REQUEST

Current Zoning: R-3 (single family residential)
Proposed Zoning: MX-3 (mixed use) and UR-2(CD) (urban residential, conditional)

Approximately 240.32 acres located on the west side of Steele Creek Rd, south of Sledge Rd, east of Shopton Rd

The petition proposes the development of a mixture of up to 550 single family attached and detached homes and 150 continuing care/retirement community units.

Technical Data Sheet - Continued  
(Sheet 3 of 4)  
Petition # 2019-128  
**GAMBRELL SITE**  
City of Charlotte, NC & Mecklenburg County, NC  
Pulte Group

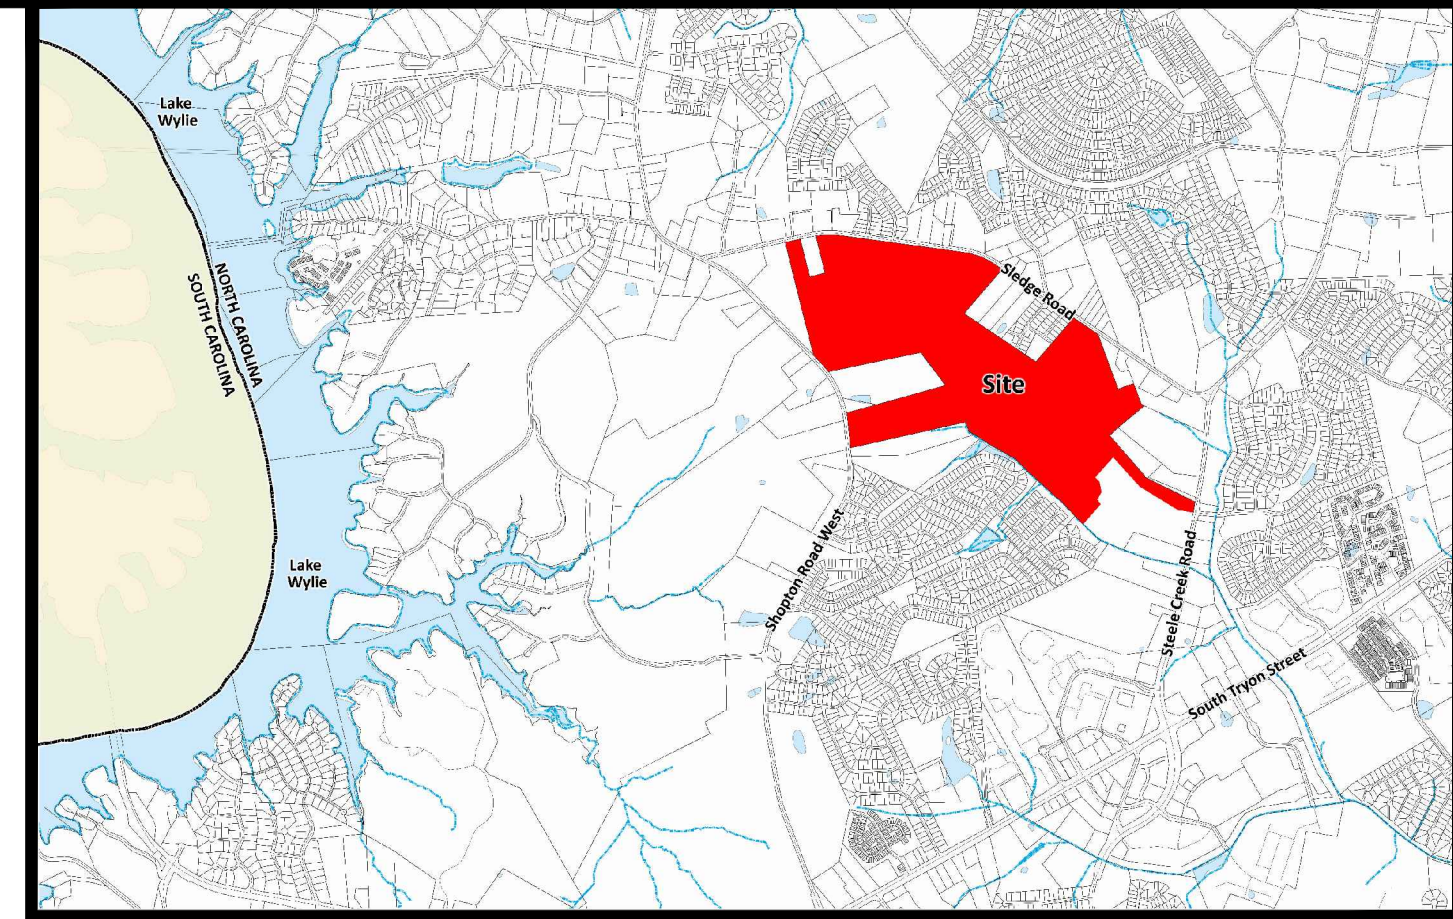
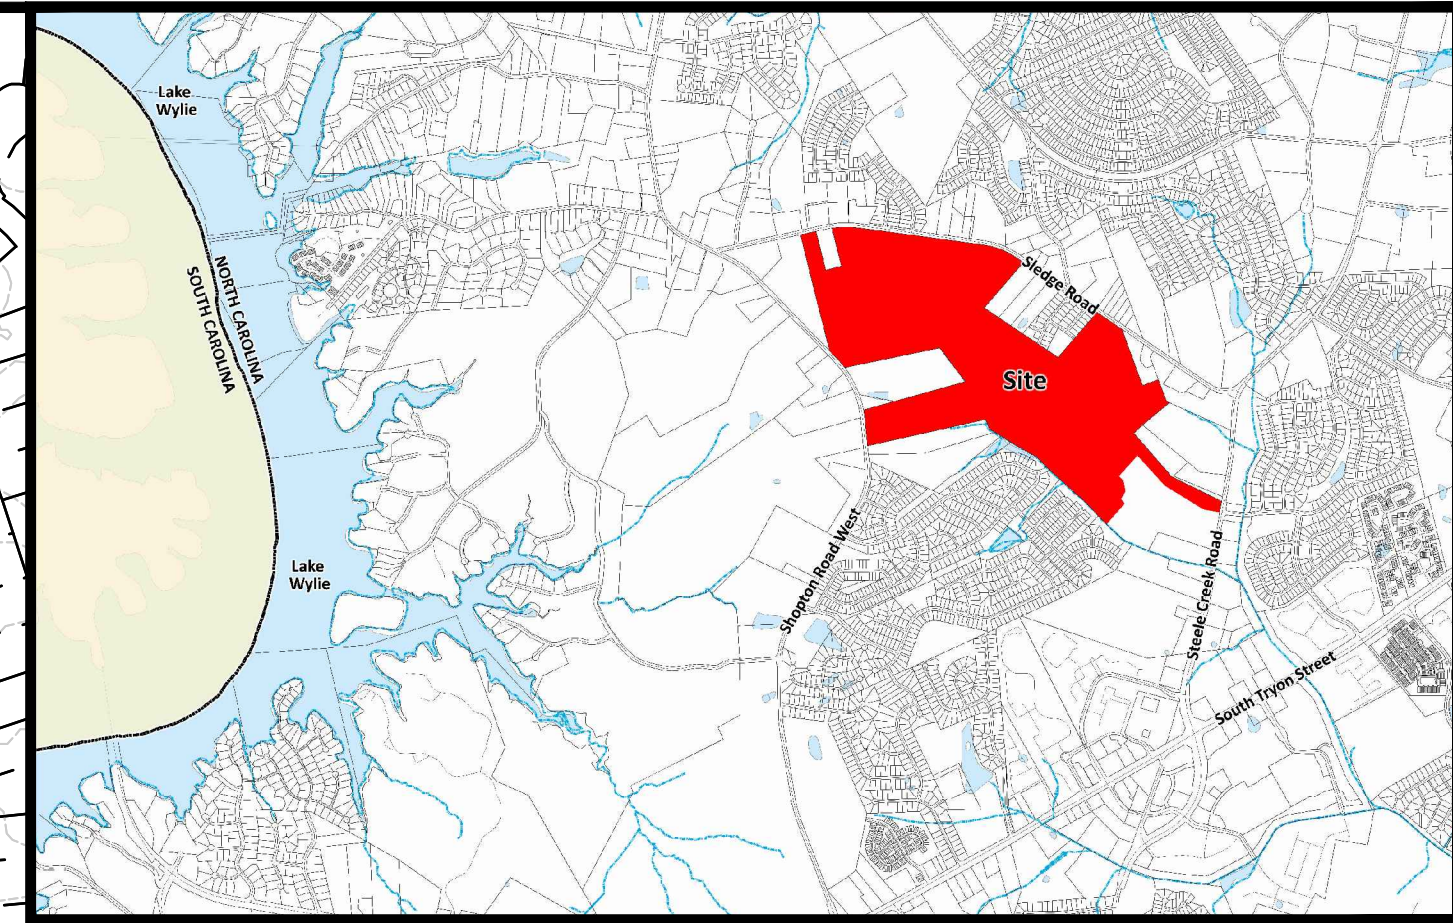
- ~~1. **Curbline** The proposed zoning district has a setback measured from back of the existing or proposed future curbline. Label and dimension the curb lines from the centerline.~~

- a. **Steele Creek Road:** The future location of curb and gutter will be constructed within the Steele Creek Road (NC 160) U-5766 project. The public meeting map and proposed cross section are provided below for reference. **ADDRESSED**

- ~~2. Dimension the right of way from the centerline. Please show this dedication in front at Access L. All rights of way, curb lines, planting strips, and sidewalks/MUPs need to be labeled and dimensioned on **all frontages/access locations**. Typ. **ADDRESSED**~~

- ~~3. The petitioner should revise the site plan and conditional note(s) to commit to construct a 6-foot sidewalk along of the frontage of Shopton Road and to establish a connection to the existing sidewalk stub provided by the existing Waterlyn Subdivision. The site plan should label and dimension both items from the back of curb and gutter and road centerline. **ADDRESSED**~~

Typical Street Sections & Land Development Standards  
Not to Scale

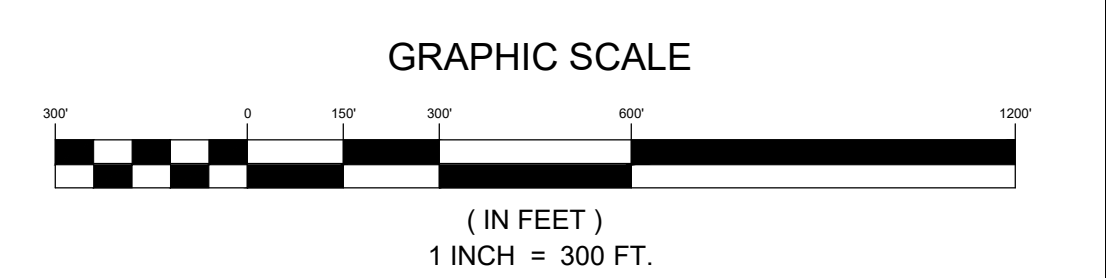
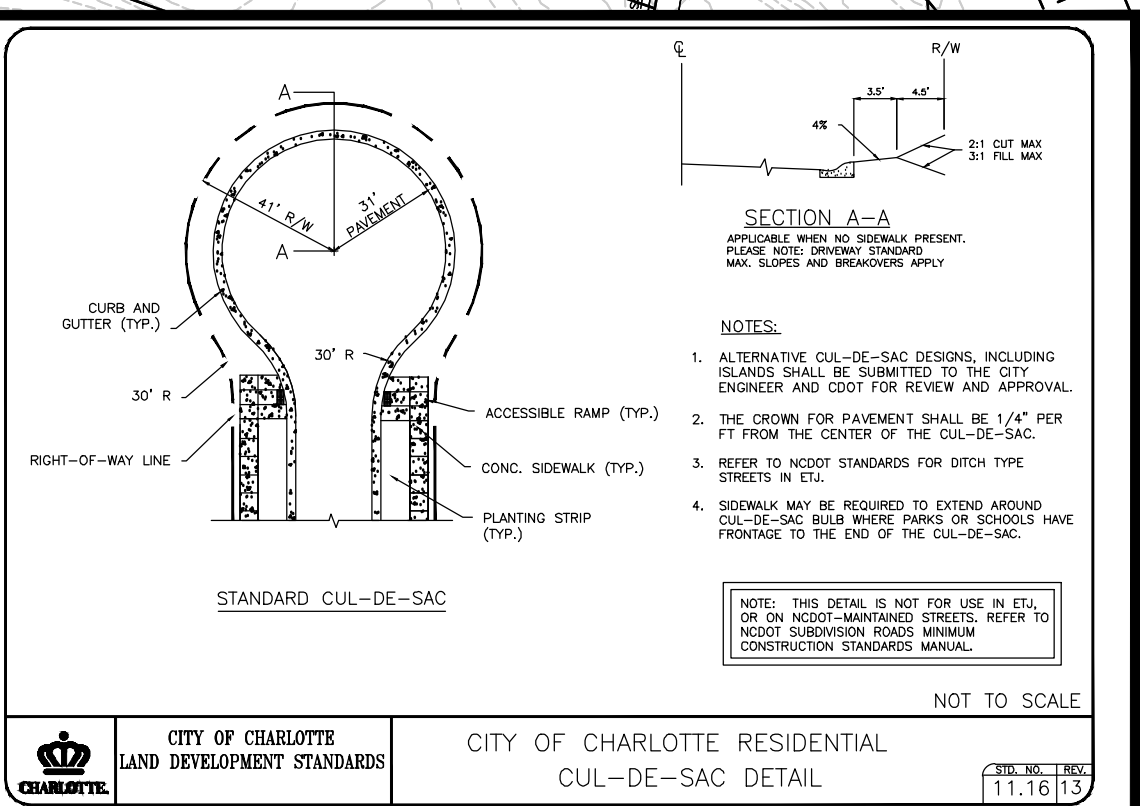
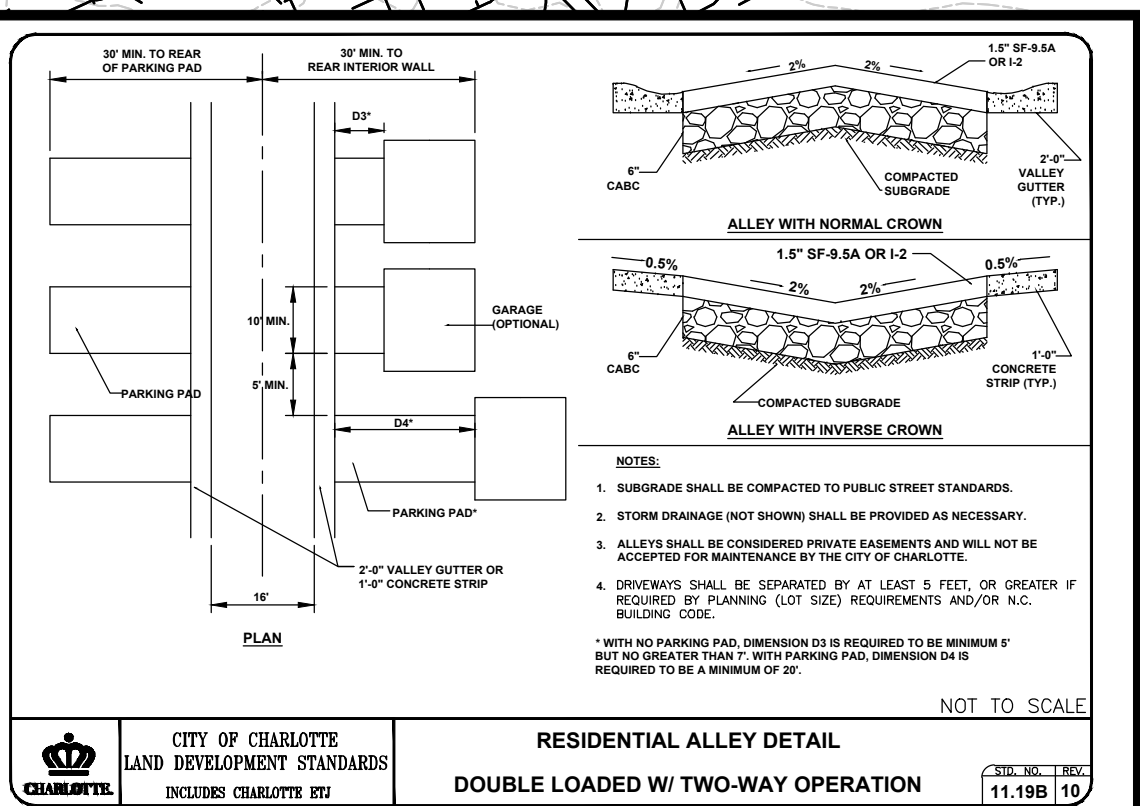
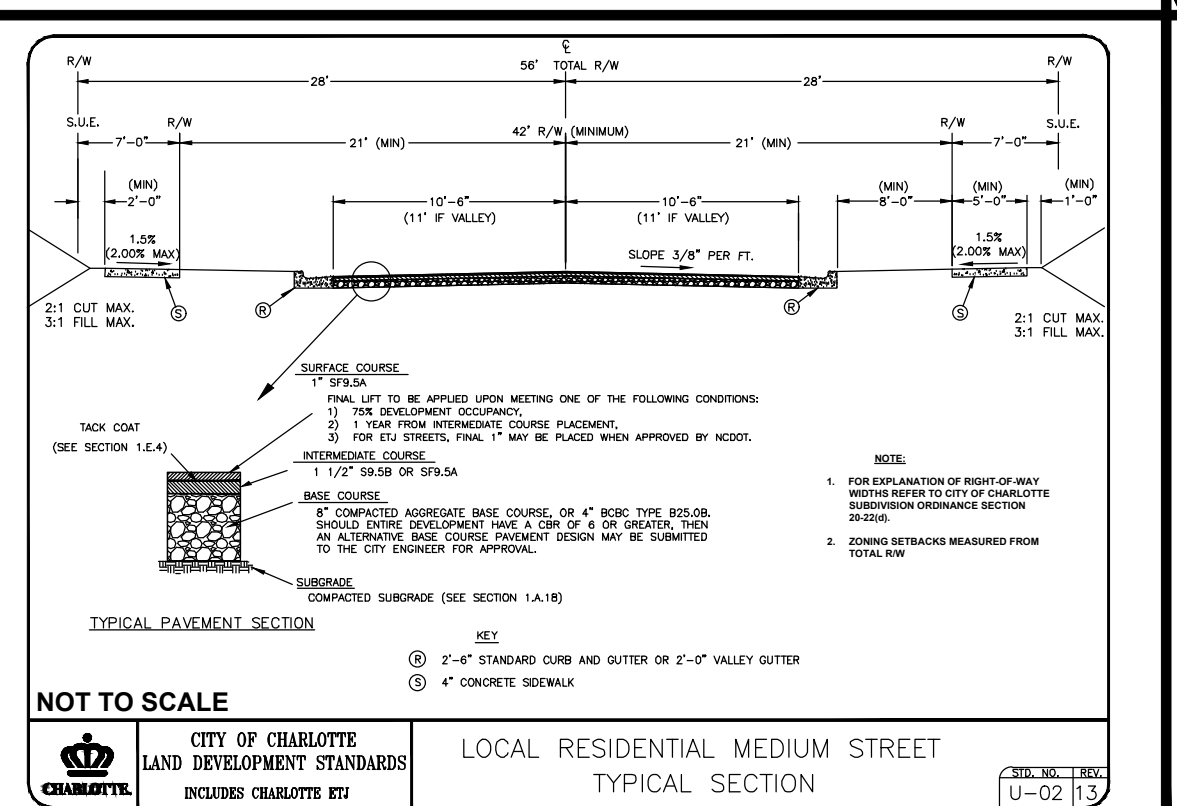
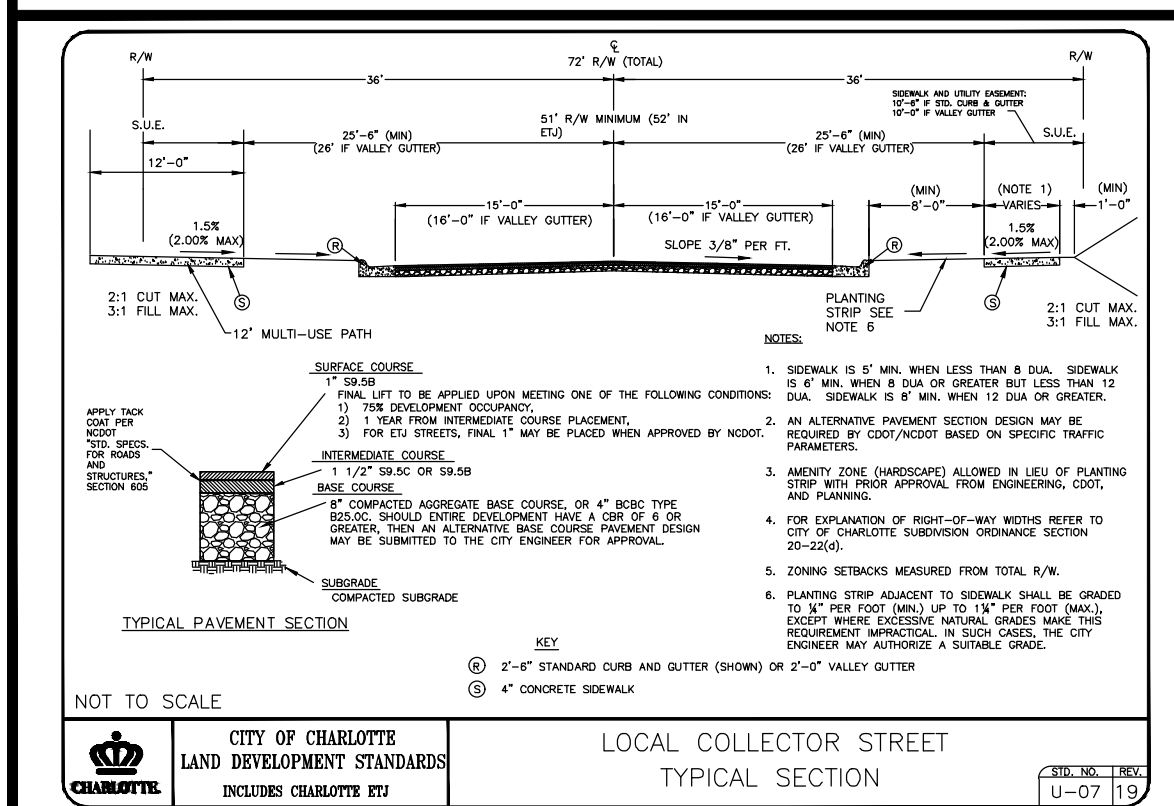
- ~~5. The petitioner should revise the site plan and conditional note(s) to incorporate a proposed mini-roundabout on proposed Public Street "A." **ADDRESSED**~~
